Letter No. **A1/11492/91**

Sub: MMDA - Planning Permission -
**Construction of Ground floor
residential building in Plot No.23
at S.No.84/2A of Valasaravakkam
village - Approved - Reg.**

SITE PLAN scale 1:16.0' (1:200)

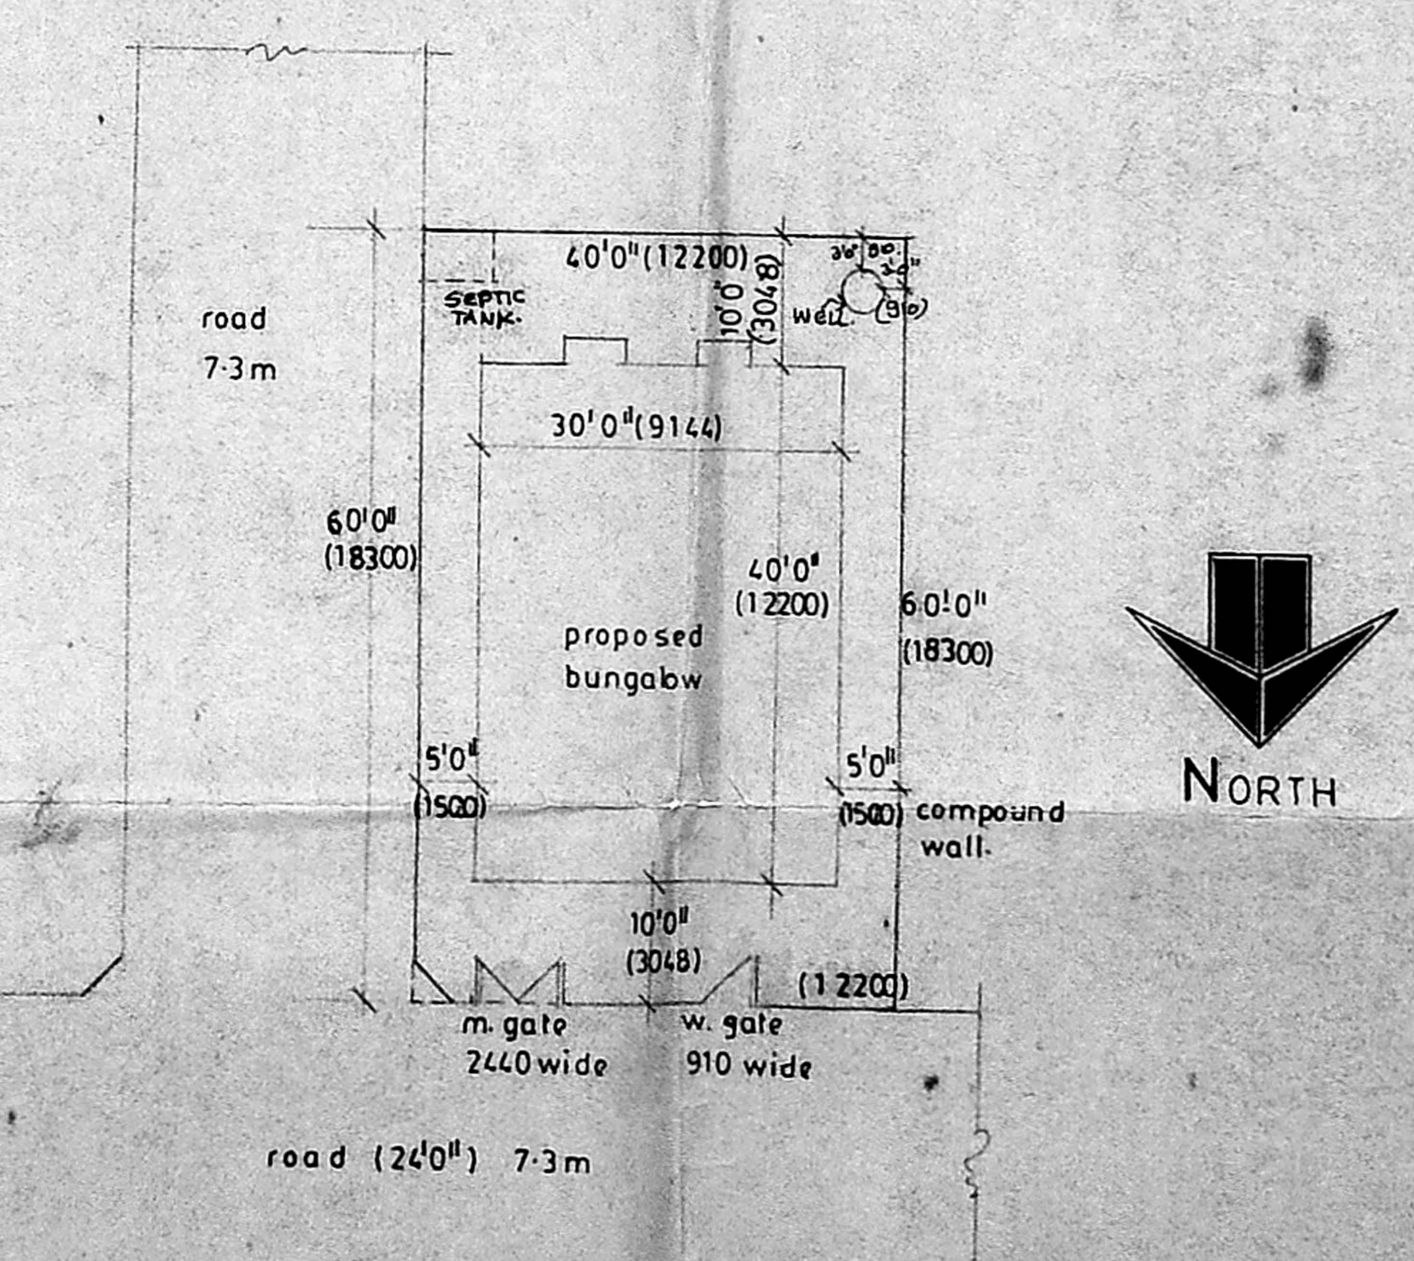
towards Regularisation charge by two separate Demand Drafts of
a Nationalised Bank in Madras City drawn in favour of the
Member-Secretary, MMDA., Madras-8 or in cash/and pay at MMDA.
office Cash Counter between 10.00 A.M. and 4.00 P.M. within
10 days and after remit the said amount, you are requested to
remit the duplicate receipt to Area Plans Unit. You are also
requested to submit the Affidavit for ULC in Rs.5/- Stamp
paper duly attested by Notary Public. Planning Permission
Application will be returned unapproved if the amount are not
paid within the stipulated time. **You are also requested to
furnished 5 sets of Revised site plan indicating the Rear Set
Back and incorporating the Survey numbered as per Patta.**
